Approval of details reserved by condition imposed under ref CM/18/19/PL relating to Condition Nos 3 - materials & finishes, 4 - covered & secure cycle parking, 7 - surface water drainage and 8 - discharge flows to watercourses.

Land at the Entrance to Waterford Gardens Horsemere Green Lane Climping BN17 5PQ

Arun District Council have decided to **REFUSE details reserved by condition for the following reasons:**

TITLE Proposed Site Layout Proposed Drainage			
SCALE 1:200		PROJECT No. 23078	
REPORT TYPE SB		DRG. No. 03 B

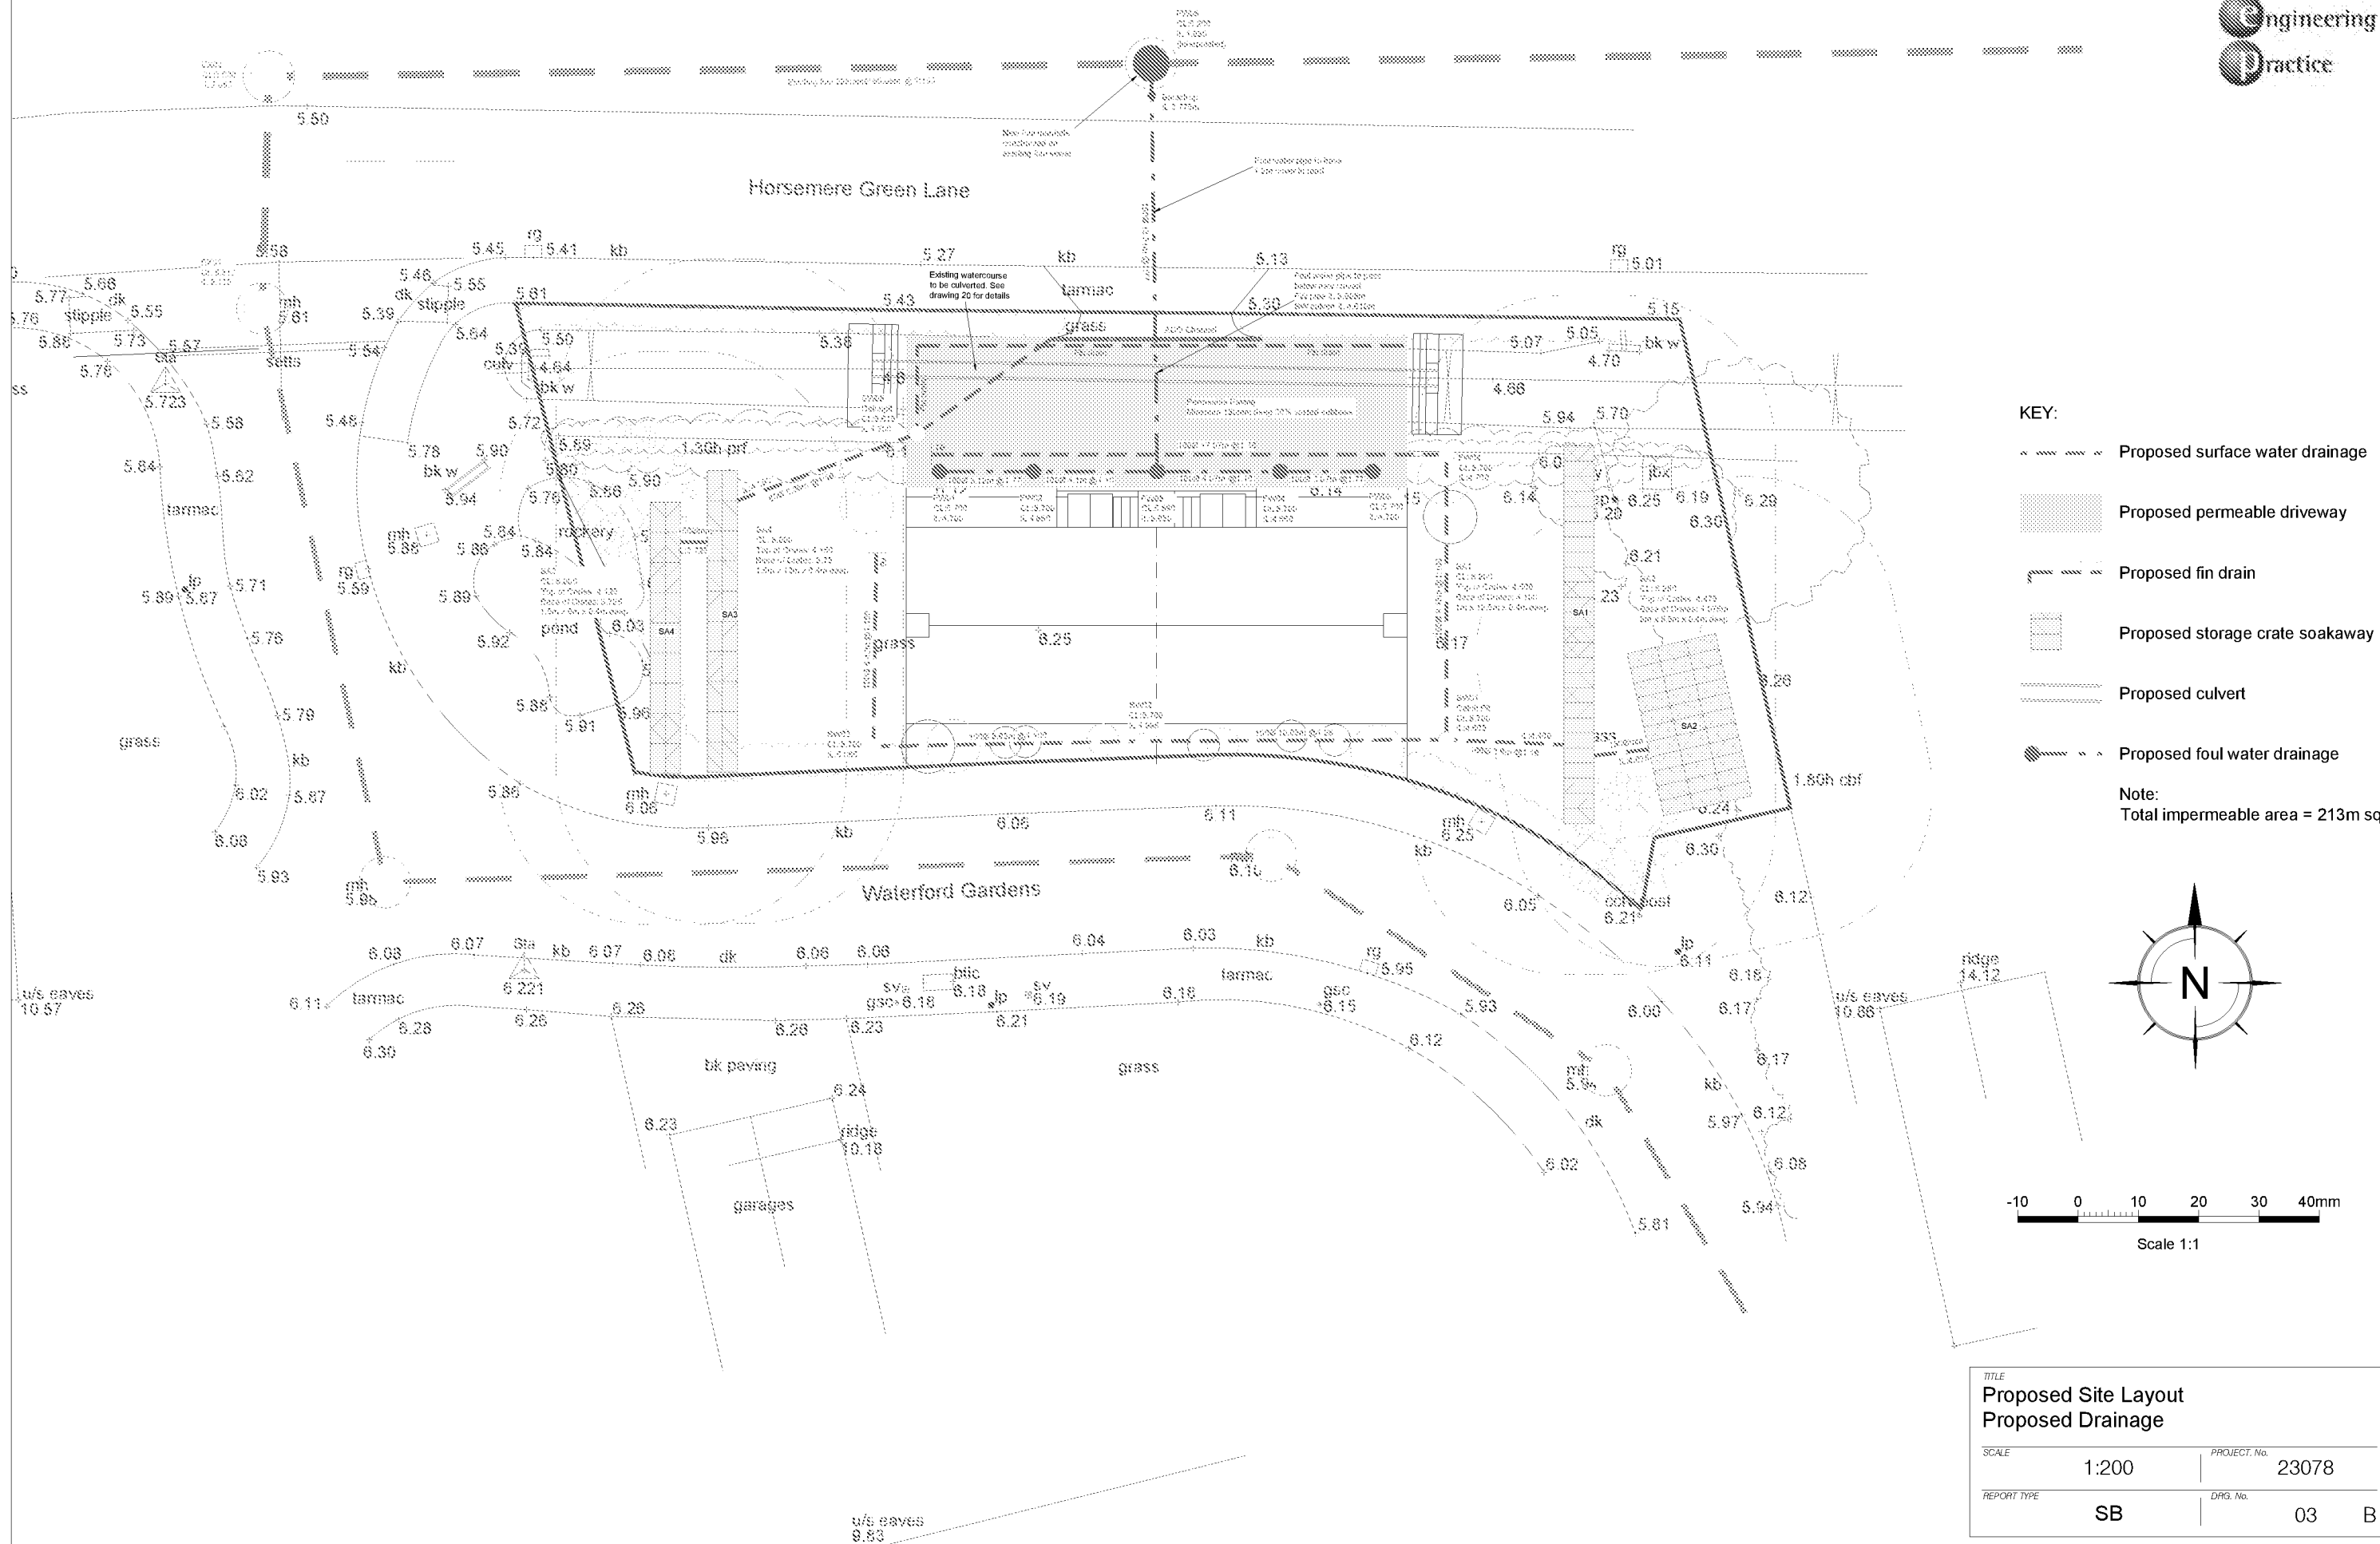
- inadequate ground monitoring had been undertaken,
- a full ground monitoring report needs to be provided,

- soakaways are set too deep,
- soakaways are located within the RPA of an established tree and hedging on site,
- soakaways are located too close to an existing pond on site,
- no construction drawings have been provided.

For the above reason and in the absence of confirmation on the acceptability of the details the condition 7 cannot be discharged and you will need to make a revised submission.
